**Re: Comment Letter for Proposed Redevelopment of 6950 SE Maker Street
Permit No. 2207-019**

On behalf of our client, Dan Grove, we submit these comments on the permit application for the proposed demolition and rebuild of the home located at 6950 SE Maker Street (the “Strand Property”) pending under Permit No. 2207-019 (the “Permit”). Mr. Grove owns the house immediately adjacent to the east of the Strand Property and is acutely familiar with the issues discussed in this letter. Mr. Grove respectfully requests notice and a copy of the permit decision once made by the City.

A 2 . 3

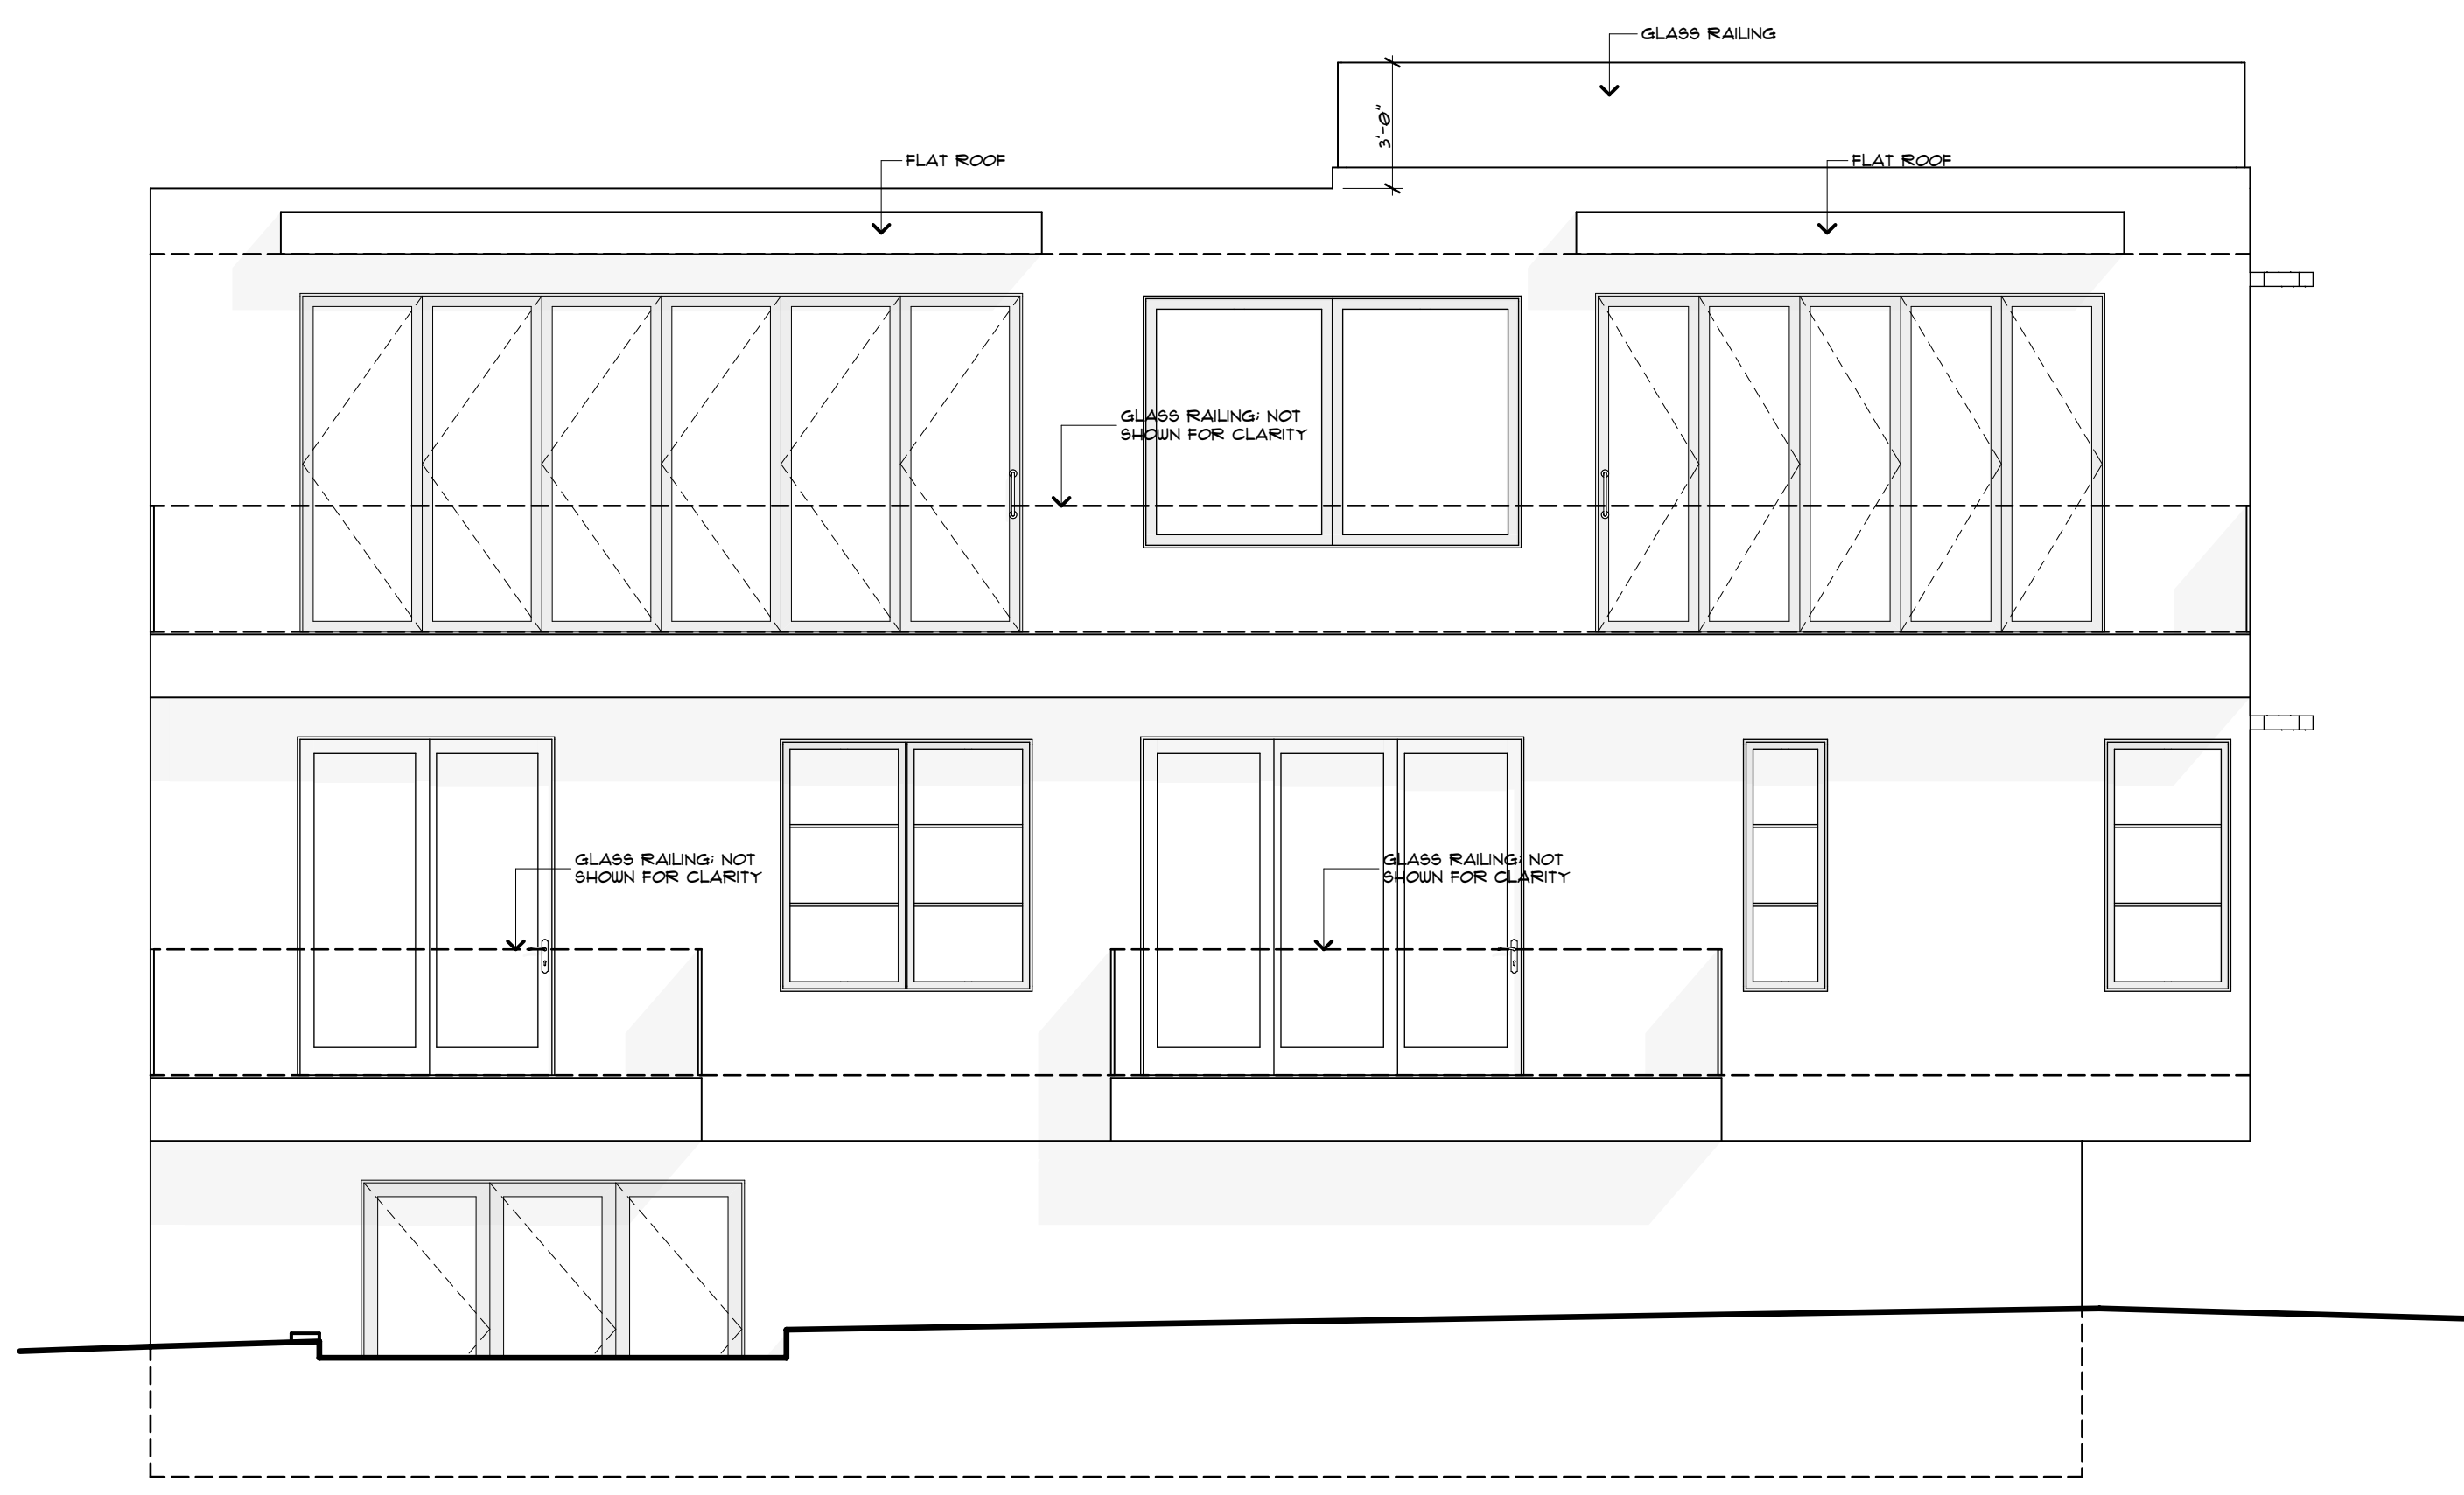
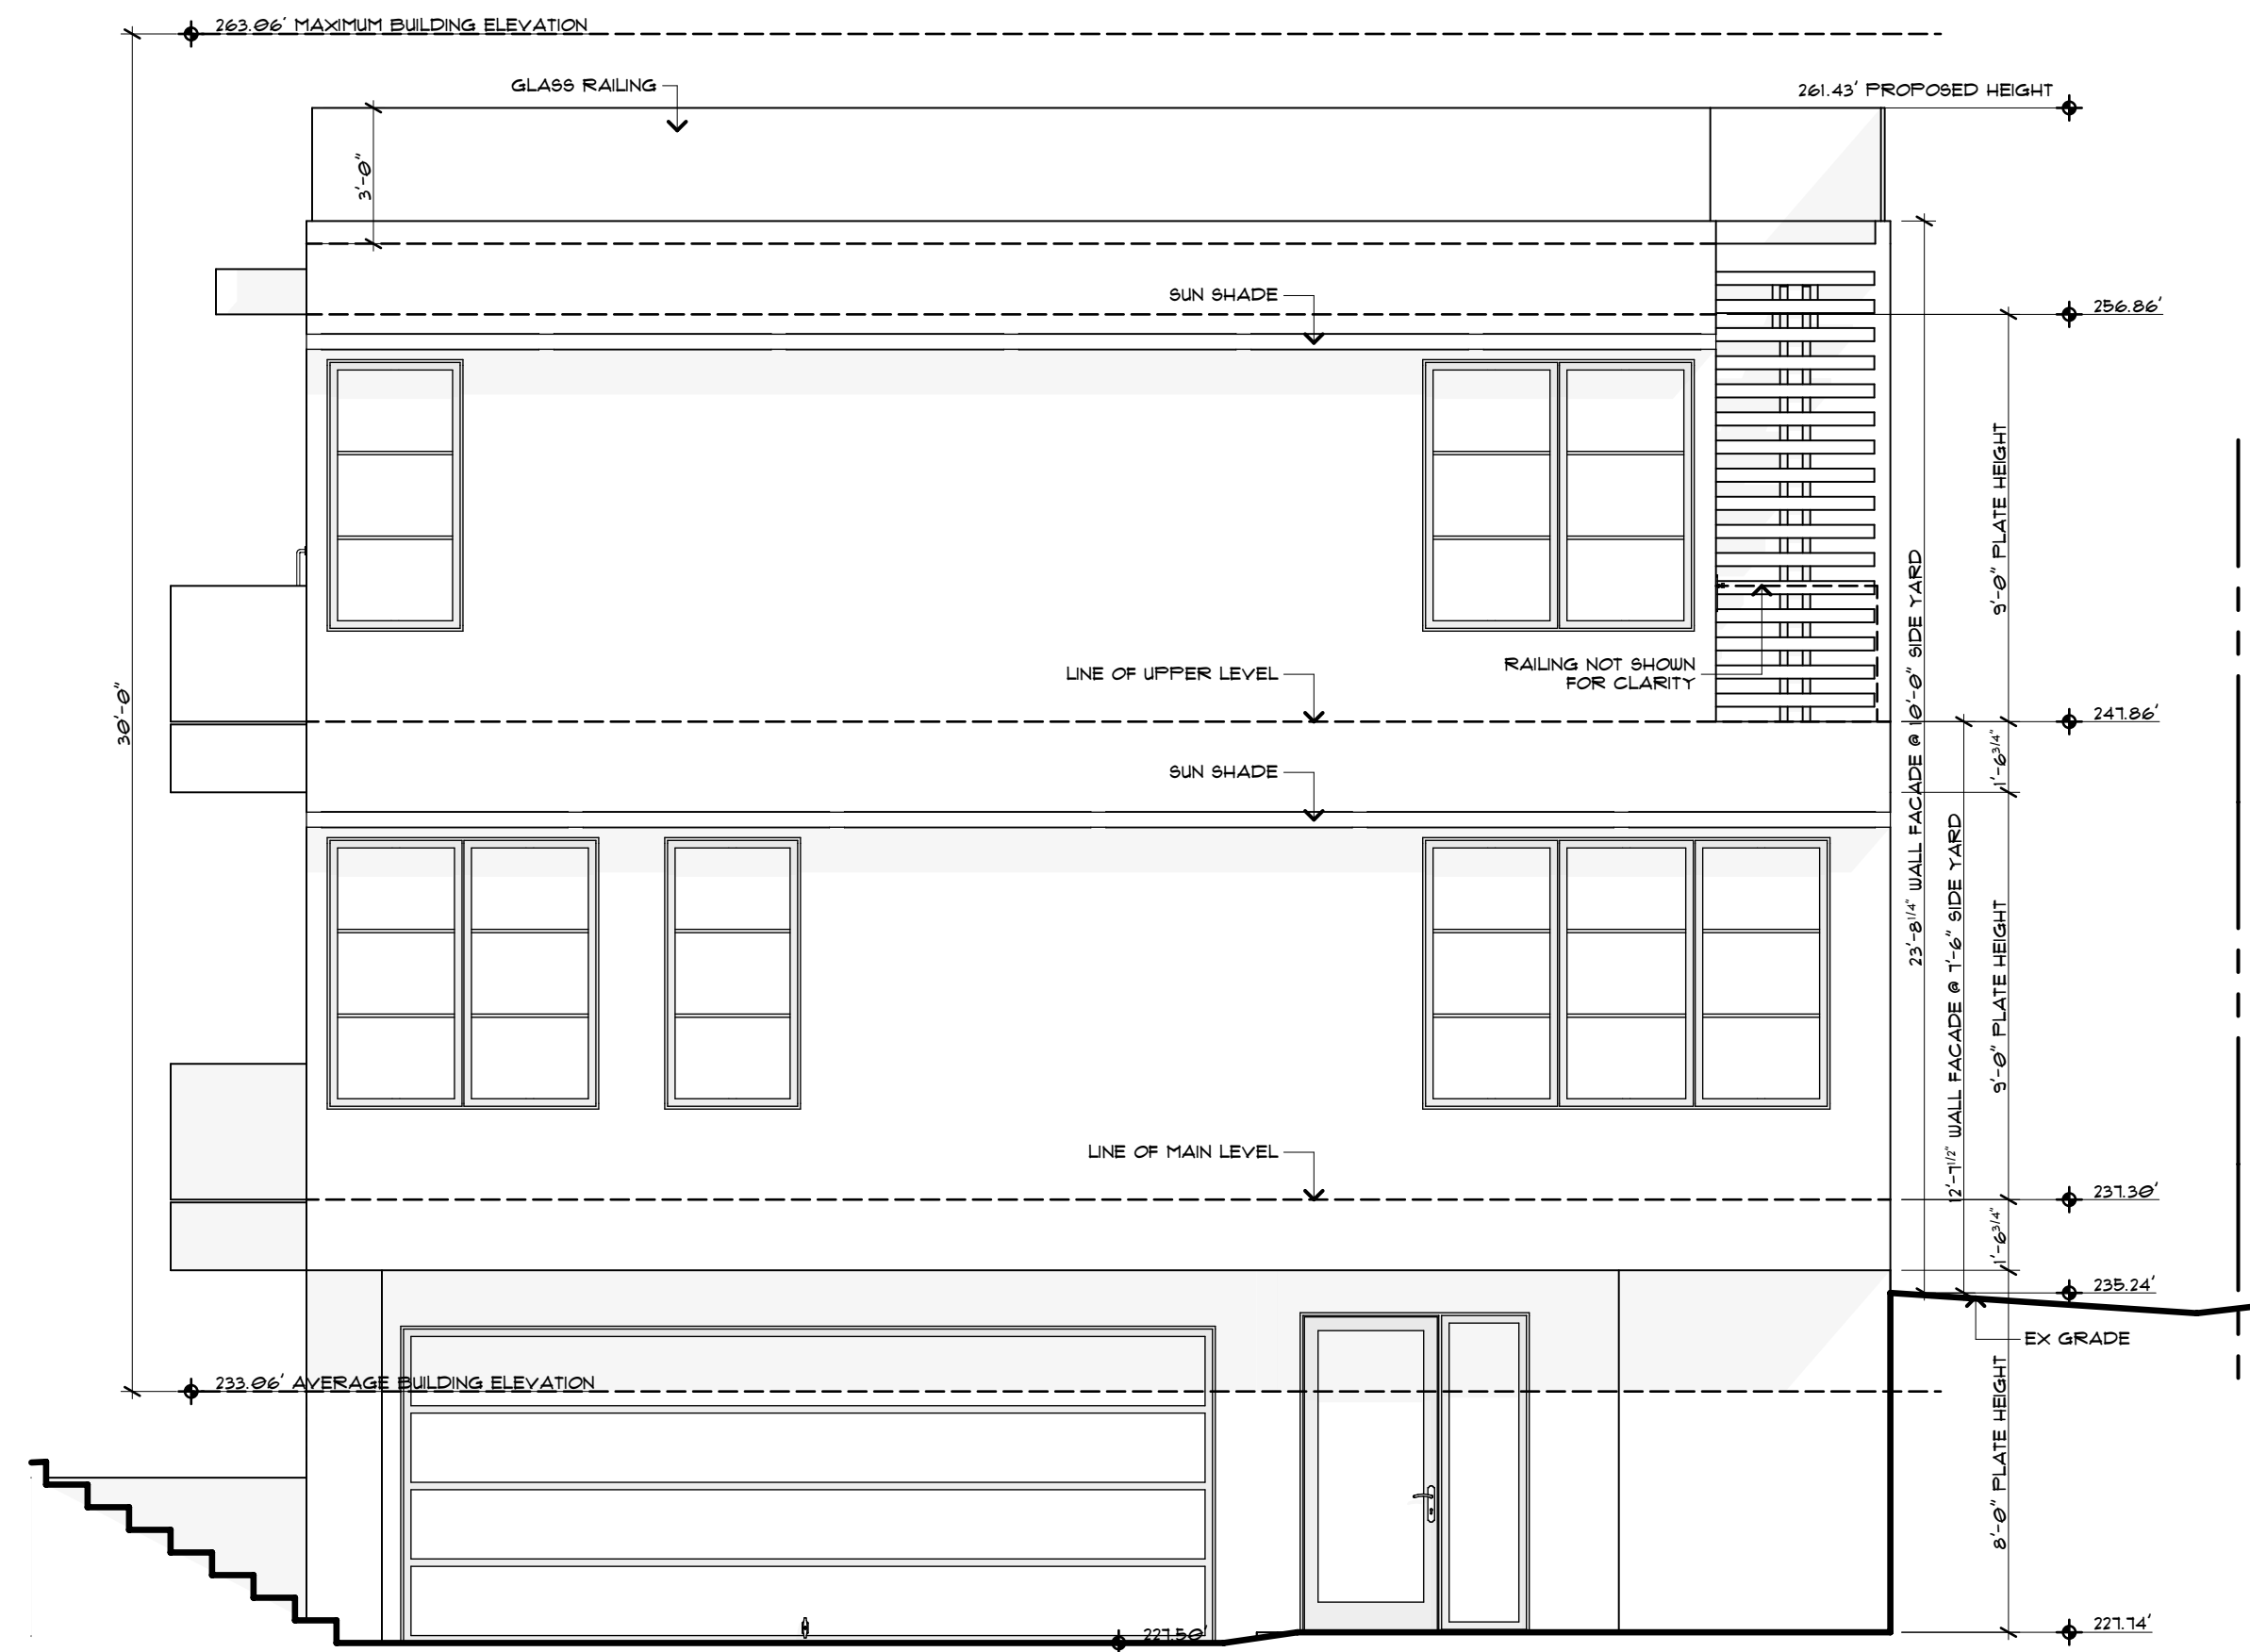
finished floor elevation of the basement as 228.7' (Sheet 1), the proposed finished floor elevation as 227.72' (Sheet C-2), and the existing grade as 235.24' (Sheet A3.1).

Evidence from pre-development survey documents shows the existing grade as several feet lower than the existing grade as calculated in the design plans. This translates to an ABE closer to 227.0’, not 233.06’ as identified in the Plan Set (Sheet A3.1).

Summary of Permit’s Incorrect Calculations	
(Inaccurate) ABE	233.06’
Height Limit	30’
(Inaccurate) Maximum Allowable Building Height	263.06’
Proposed Height	261.43’

But, instead of 263.06', the correct maximum allowable height is closer to 257.0' because the ABE is more accurately 227.0'. The relevant surveys and design plans show the correct calculations for this project are as follows:

The Strand Property slopes down primarily from east to west. The existing grade at the furthest downhill extent of the proposed building ranges from 223' to 261.43'.¹² And, the rooftop railings described in the Plan Set add approximately 3 feet to the structure (Sheet A3.1). Measuring from the existing grade at the furthest downhill extent to the top of the exterior wall façade equals roughly 8 feet above the allowable 30-foot limit. The table below provides this comparison:
